CITY OF ALBUQUERQUE

December 13, 2006

Re: Mixed Use Condominiums / Commercial, Engineer's Stamp Dated 12-4-06
Lot 2A1B2B2 of Albuquerque West Unit 2, (C13/D16F)

GRADING AND DRAINAGE PLAN

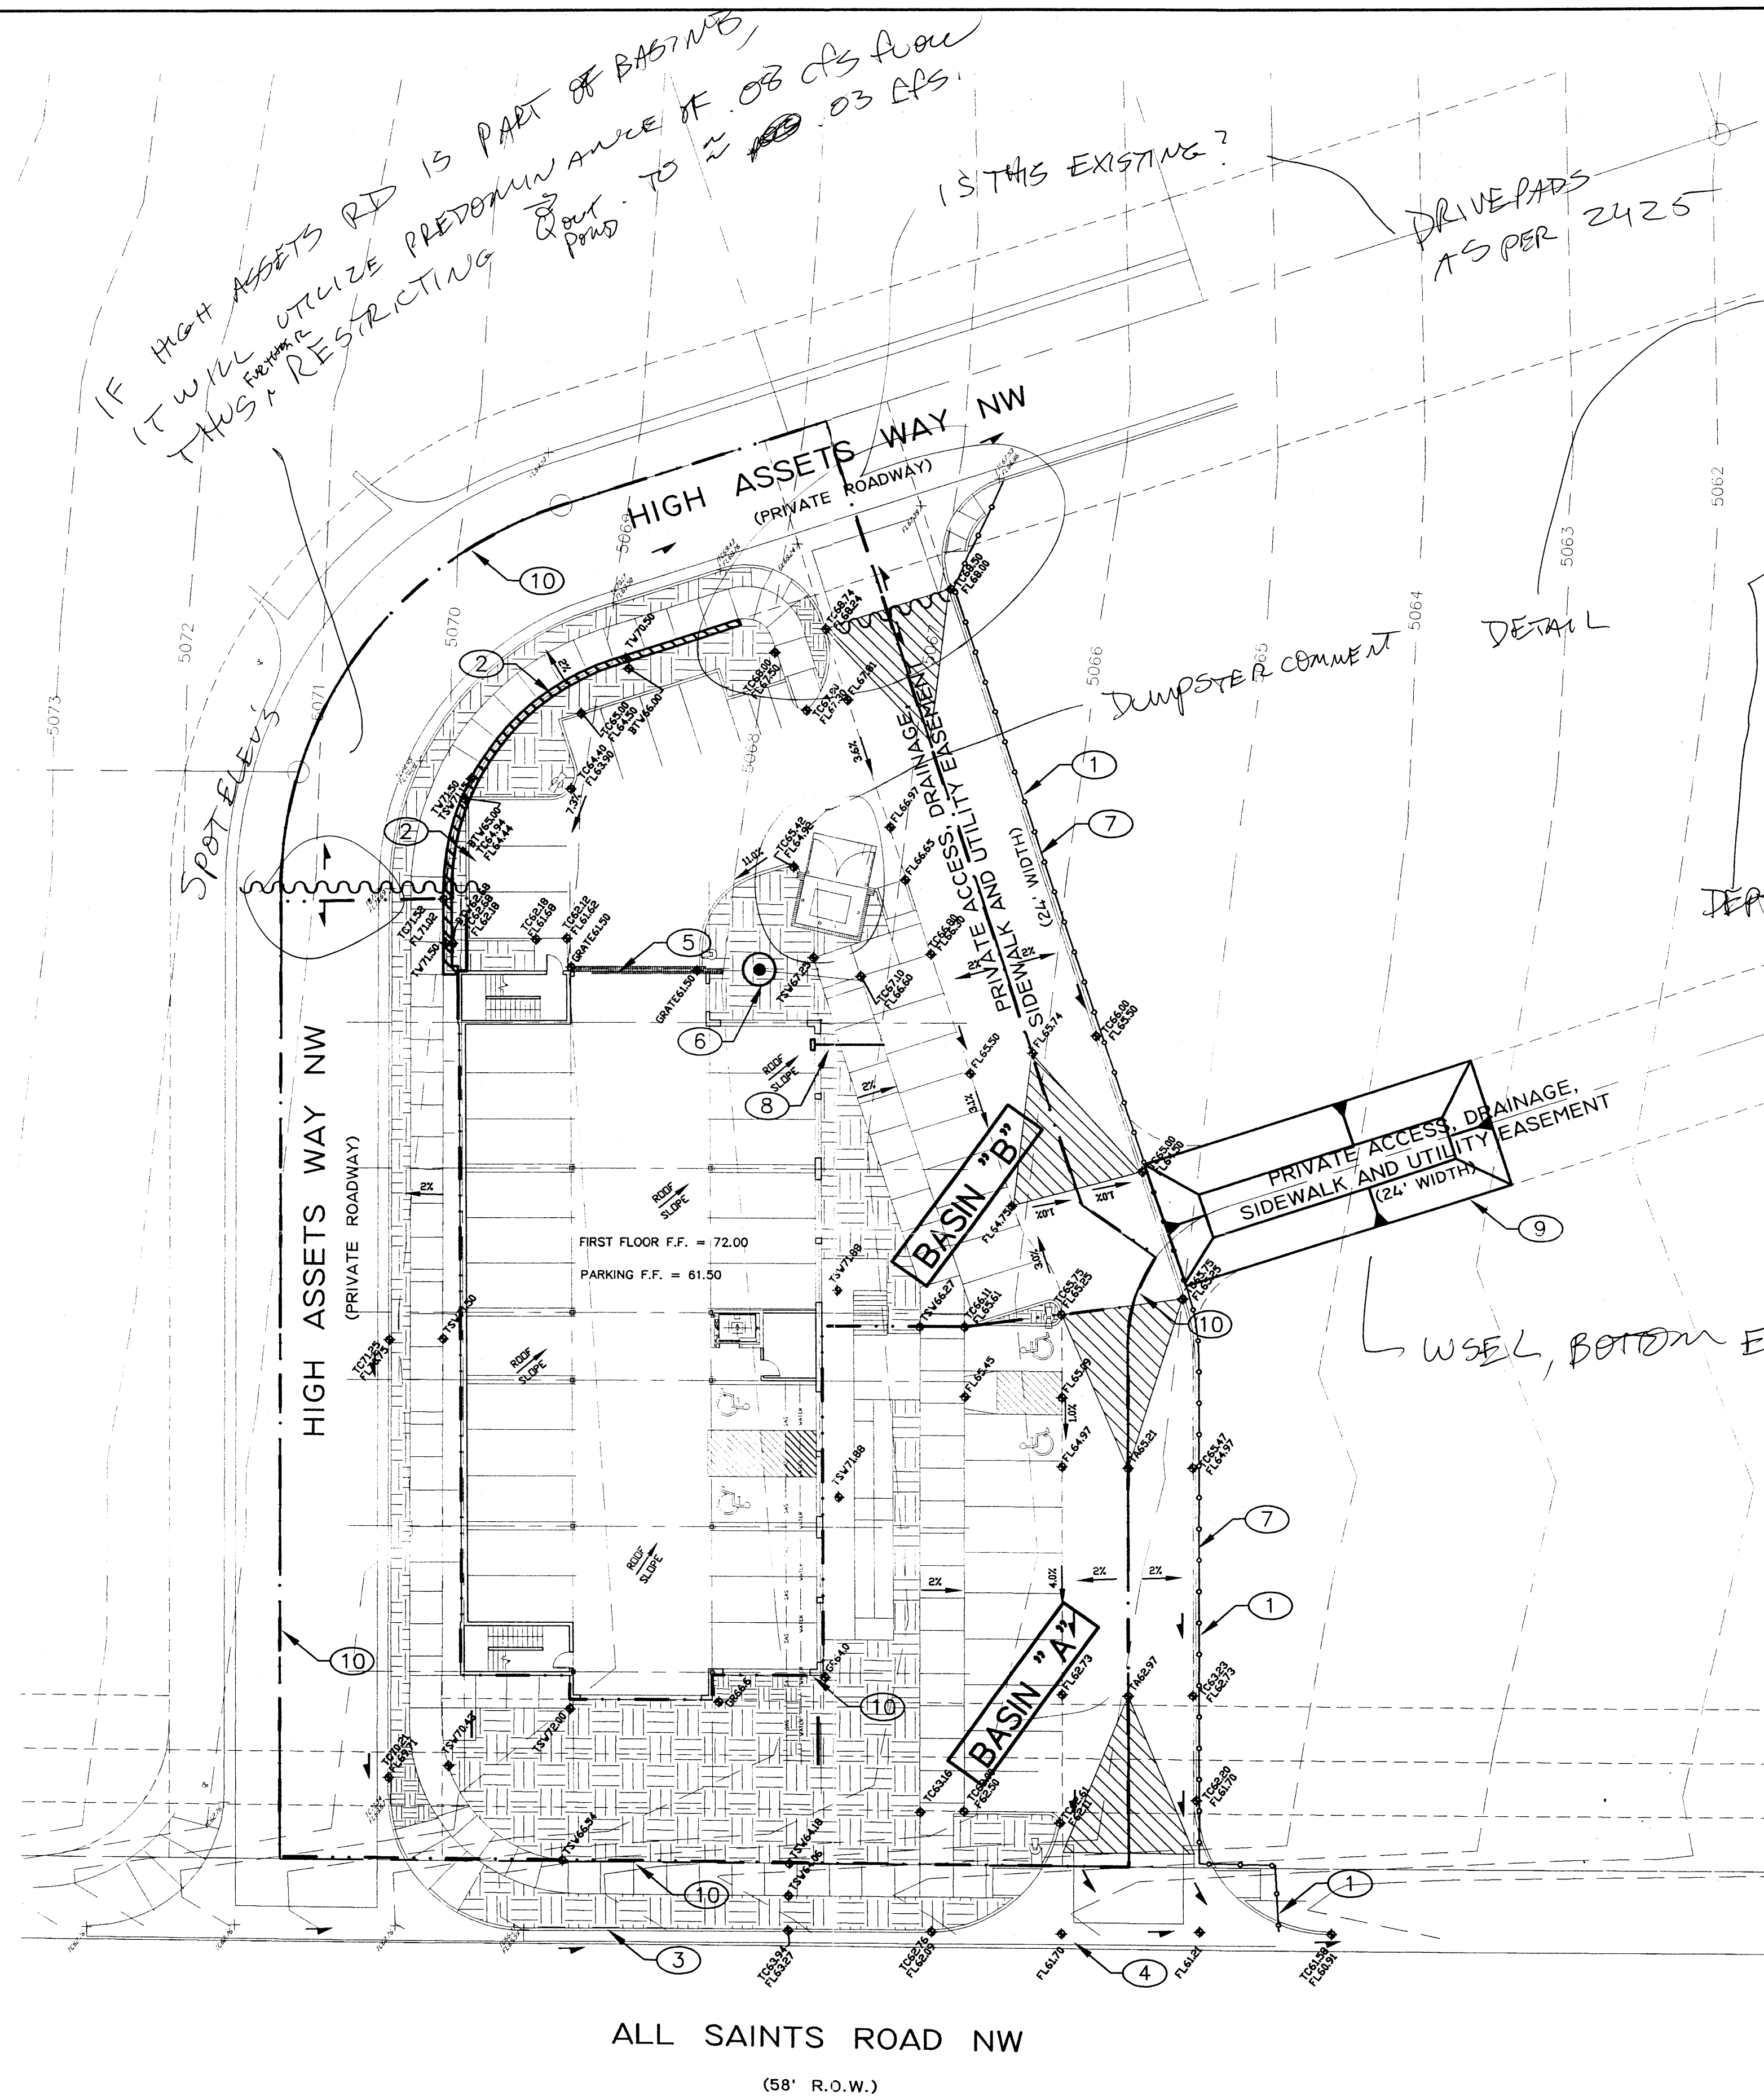
- Please cite the permanent benchmark used for the determination of the elevations.
- Please show the property line(s) on the plan or provide a copy of the plat.

- Please provide the pertinent spot elevations for the proposed grade break in High Assets Way.
- You indicate that High Assets Way is included in the two (2) drainage basins. It is my understanding that flows associated with this roadway were addressed in the Master Plan separately from the individual lots and do not affect the discharge limitation for your site. Please revise the basin boundaries accordingly and show the basin boundary line type in the legend.

- Please provide a cross sectional detail of the proposed retaining wall(s) and a detail for the proposed trench grate.
- Please call out the appropriate standard drawings for the valley gutters, sidewalks, and drive pads as applicable. Is the northern drive pad existing or will it be constructed with this project. Please specify on the plan.

- What are the elevations (top and bottom) associated with the new manhole described in note 6?
- Please provide the pump specifications / head curve for the proposed sump pump. What are the sizes and invert elevations of the pipes from the grate to the manhole and from the sump pump to the discharge location.

- Runoff from dumpster enclosures may not be routed into storm drains but must drain to the sanitary sewer system. As such, a detail of the enclosure with corner and grate spot elevations, along with a connection to the sanitary sewer, must be shown on the Grading and Drainage plan.

- Your plan calls for the construction of a temporary detention pond. Detention ponds must drain. Is this intended to be a temporary retention pond instead? Where will the permanent pond be located and how will it be accessed? Please show the location on the plan.

- The location of the proposed temporary pond within the access easement would preclude access to the adjacent lot. Although it is understood that each lot has common ownership, access must be maintained. Furthermore, an agreement / contractual obligation / covenant must be put in place to ensure the future relocation of the pond in the event of transfer of ownership to an outside party

- What will be the pond bottom and water surface elevations?

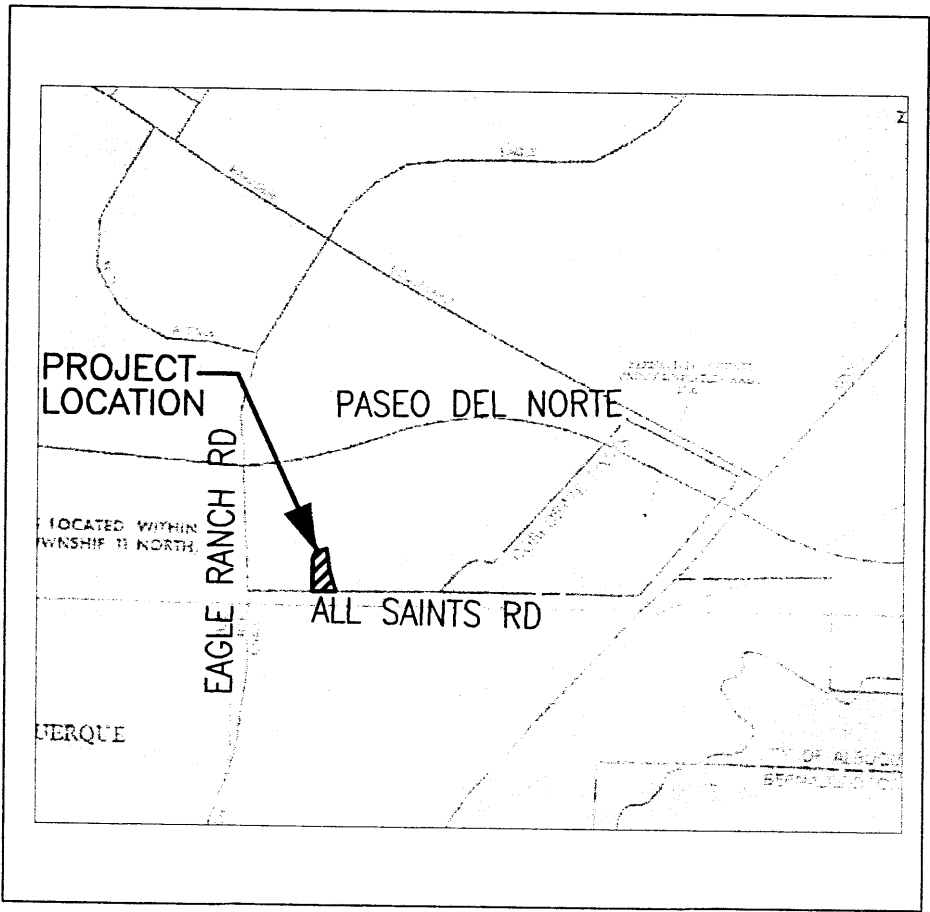
- Your calculations utilize the correct values but you reference precipitation zone 2 when your site is in zone 1. This appears to be only a typographical error.

- You indicate that Basin B will discharge at a flow rate of 0.08 cfs. However, it appears that all of this flow from Basin B will be routed into the pond. Is this the reason why the pond is to be designed to accept the entire 100-year, 6-hour runoff volume of 3,315 ft³ without adjusting for the volume associated with the 0.08 cfs discharge? How will this change in the future?
